WEST SUSSEX COUNTY COUNCIL CONSULTATION

TO:	Arun District Council FAO: David Easton
FROM:	Highways, WSCC
DATE:	30/08/2018
LOCATION:	Land West of, New Barn Lane, Bersted, West Sussex
SUBJECT:	BE/77/18/PL Erection of 10 No. dwellings & associated works.
DATE OF SITE VISIT:	
RECOMMENDATION:	☐ Advice ☐ Objection ☐ Modification ☒ No Objection ☐ More Information ☐ Refusal
S106 CONTRIBUTION TOTAL:	N/A

DRAWING TITLE
Plot 80
House Type 2BBc
Floor Plans & Elevations

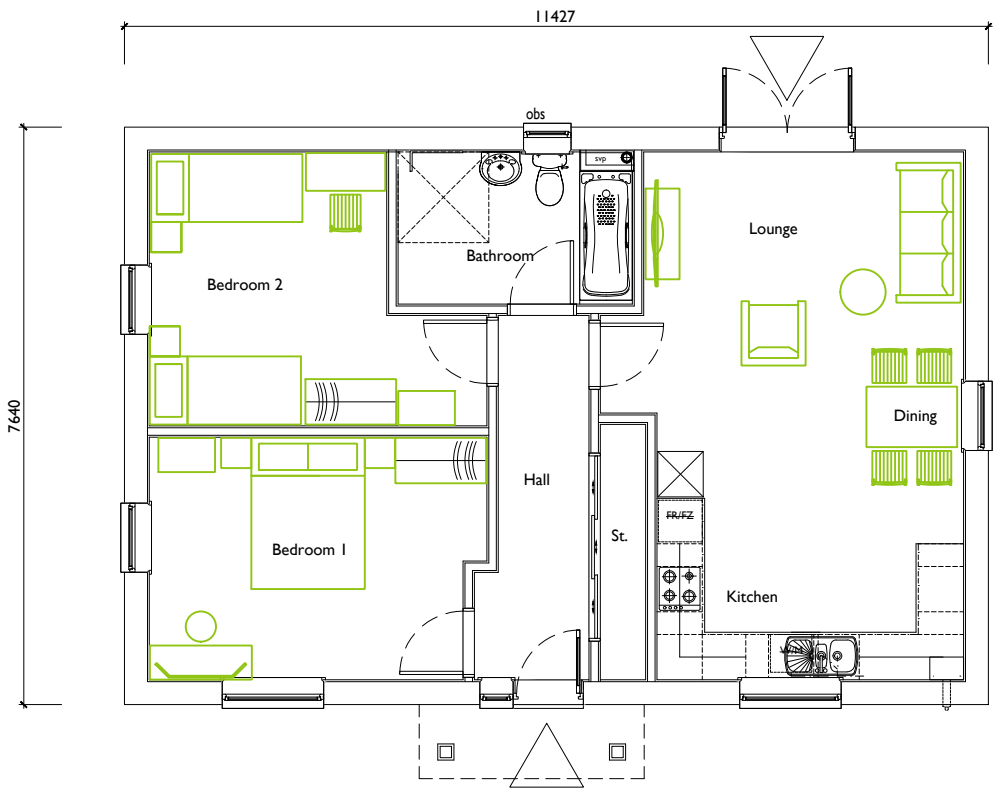
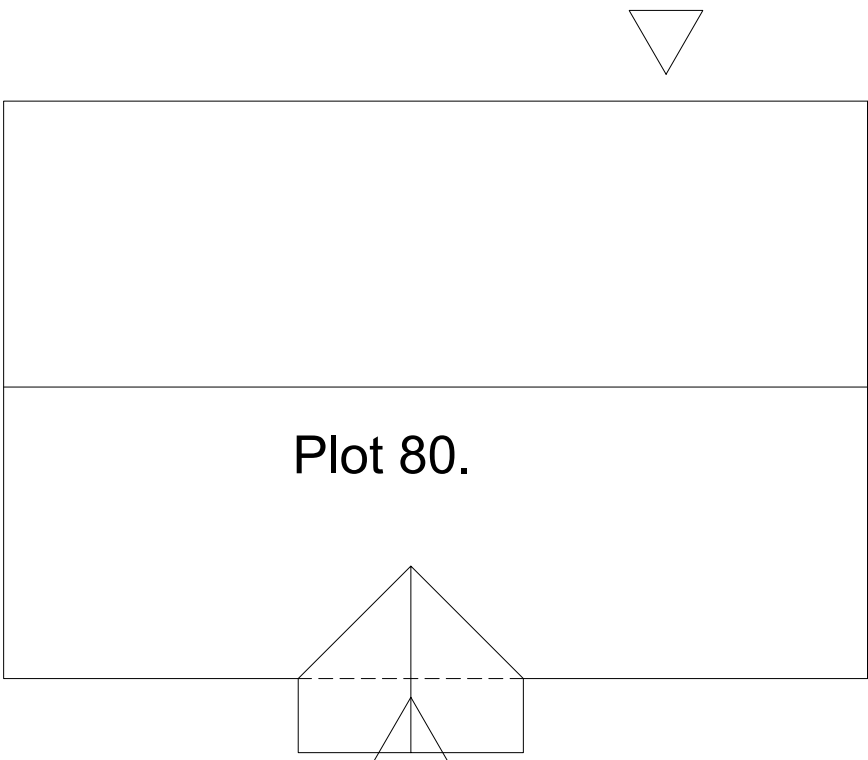
The applicant is proposing cycle parking in rear gardens of the properties which are accessible via side access ways. Further details of the specific nature of the cycle parking could be secured via condition to ensure they are policy compliant. Where garages are proposed, for properties 80 and 81, it is intended that cycles will be stored

in the garage. The garages are of sufficient size (6m by 3m) to accommodate this and are therefore deemed acceptable.
